## Pre-Design Investigation

DATE 10-19-82ADDRESS 78.5 McNAUL N.E. ZONE ATLAS # H-19-020

PROPOSED DEVELOPMENT ADDITION 1200 ft<sup>2</sup>

D E S C R I P T I O N   O F   W O R K : move metal building. (new) wheel alignment facility

7815 MENAULALBUQ.	DRAWING NUMBER I
-------------------	---------------------

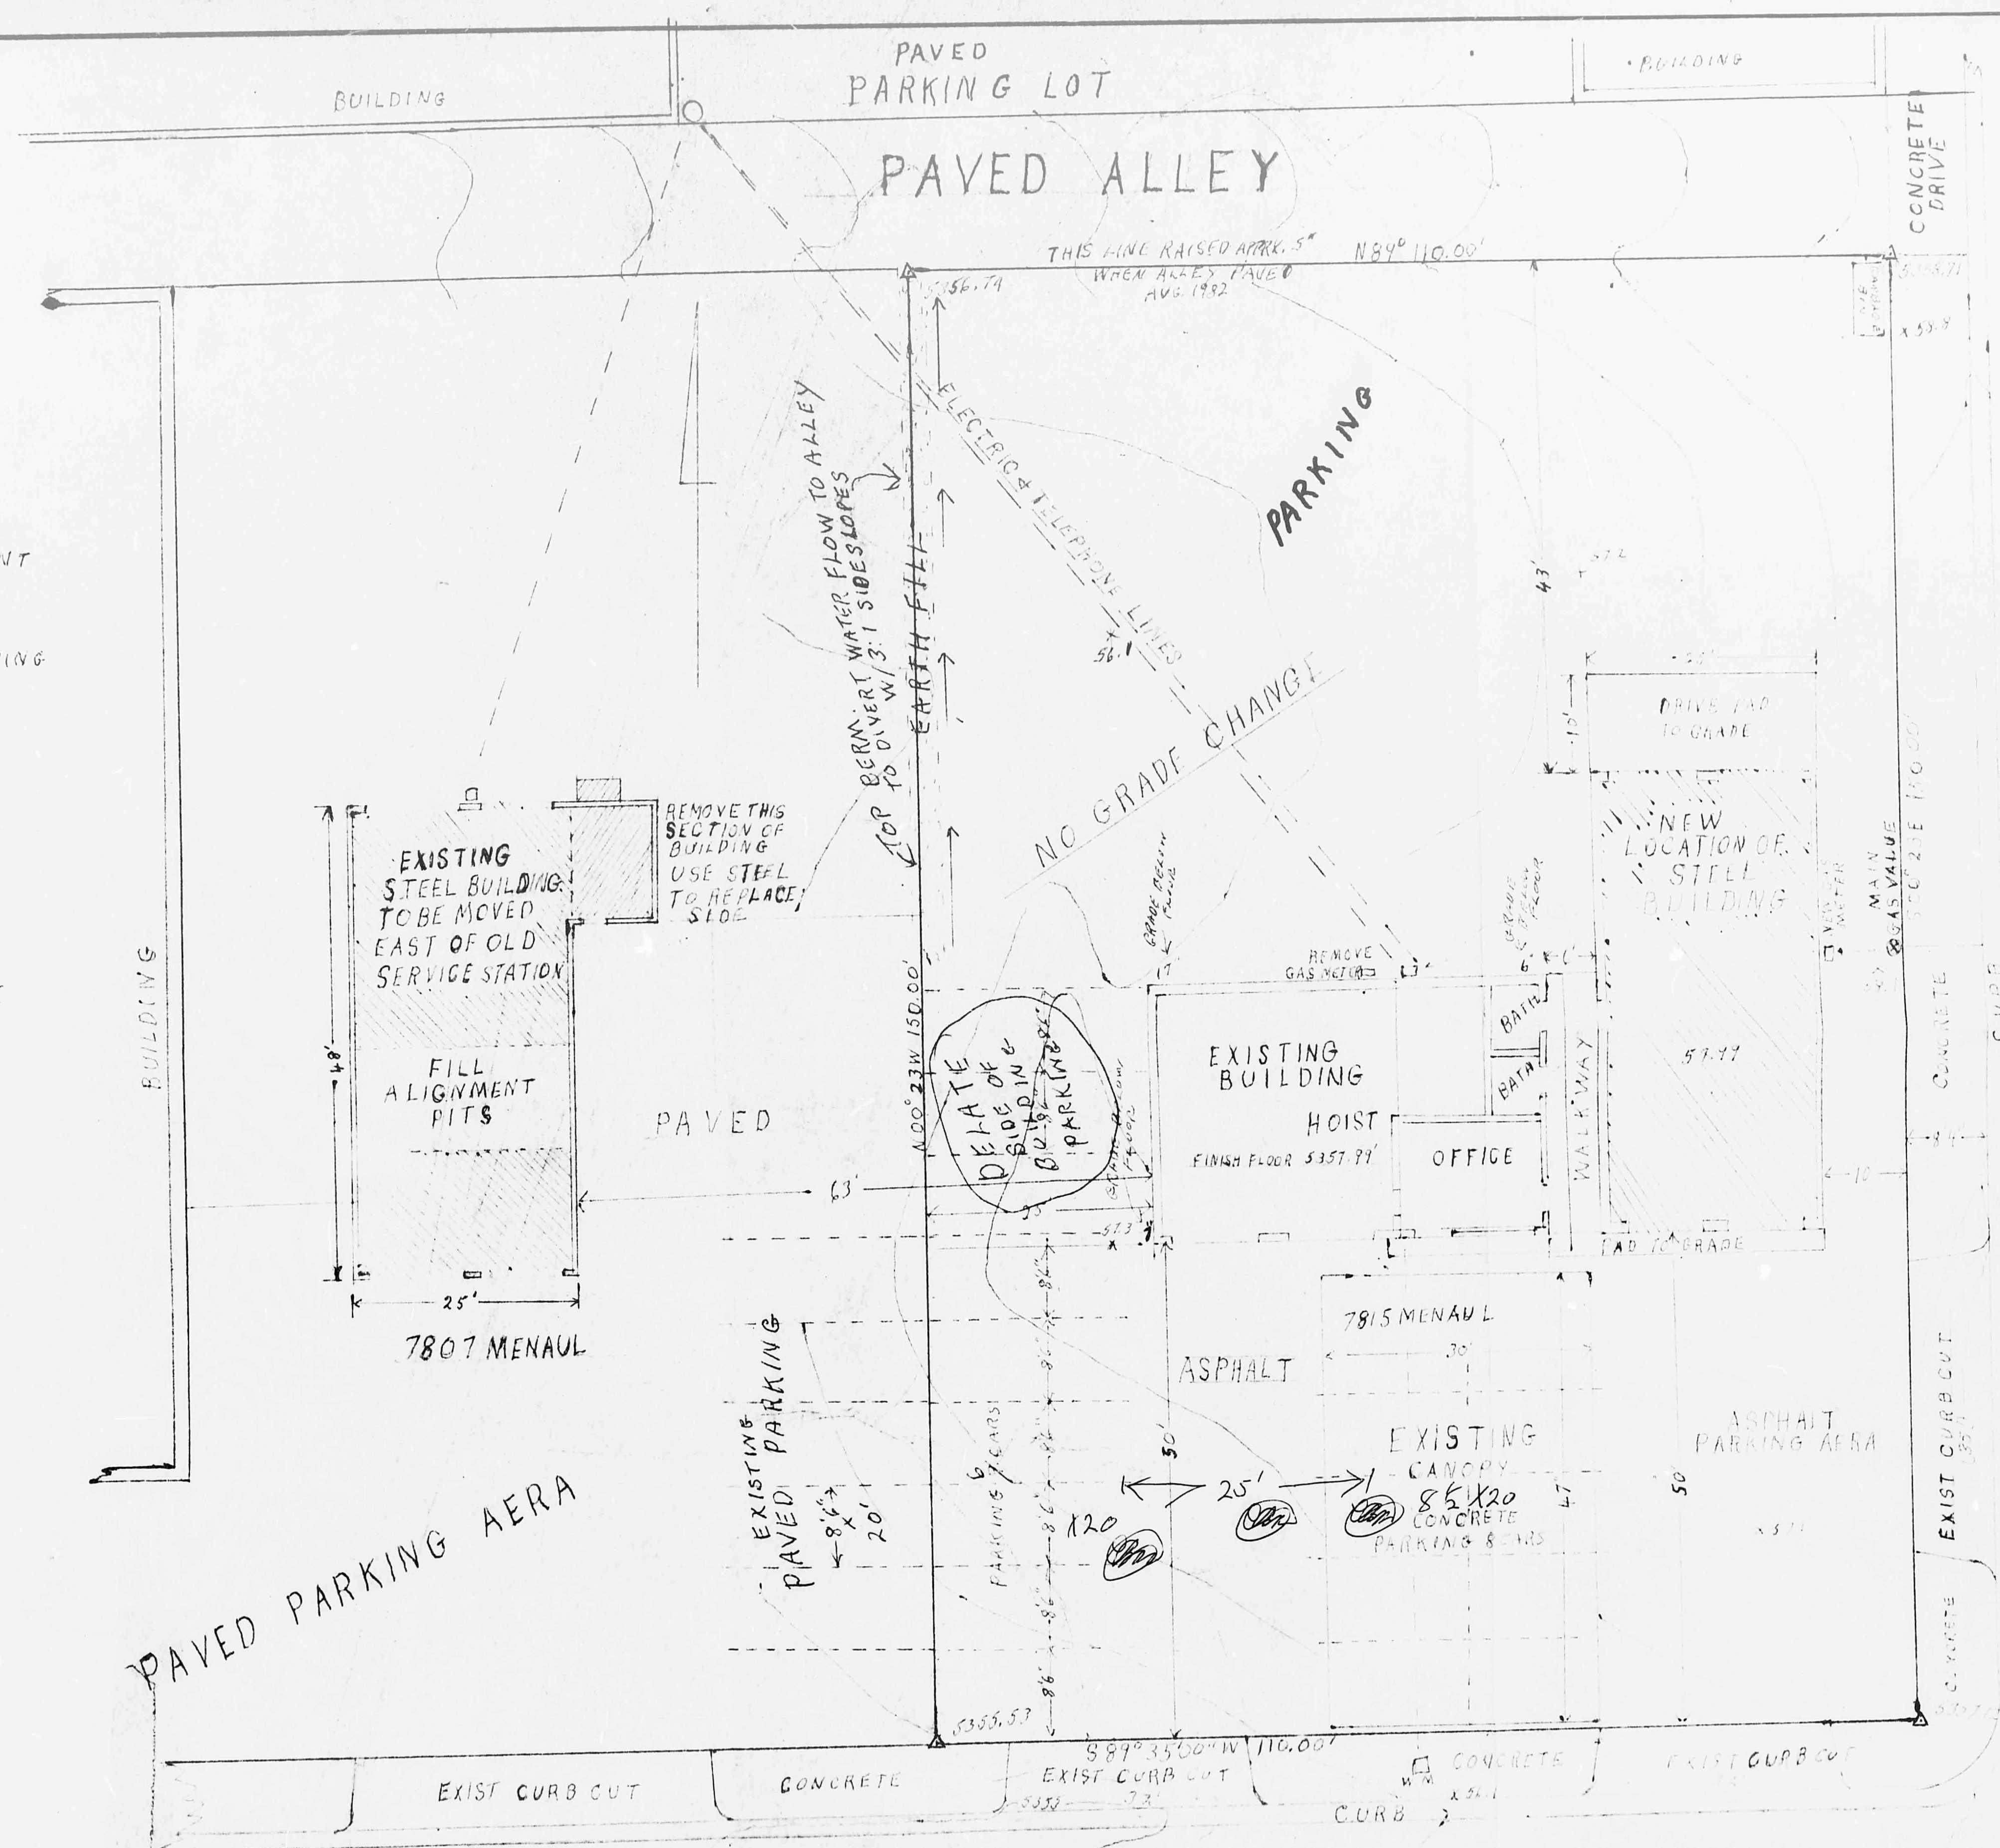
REQUIRE DISCHARGE FROM NEW ADDITION INTO THE  
CITY STREET OR T&E ALLEY. 10/20/82
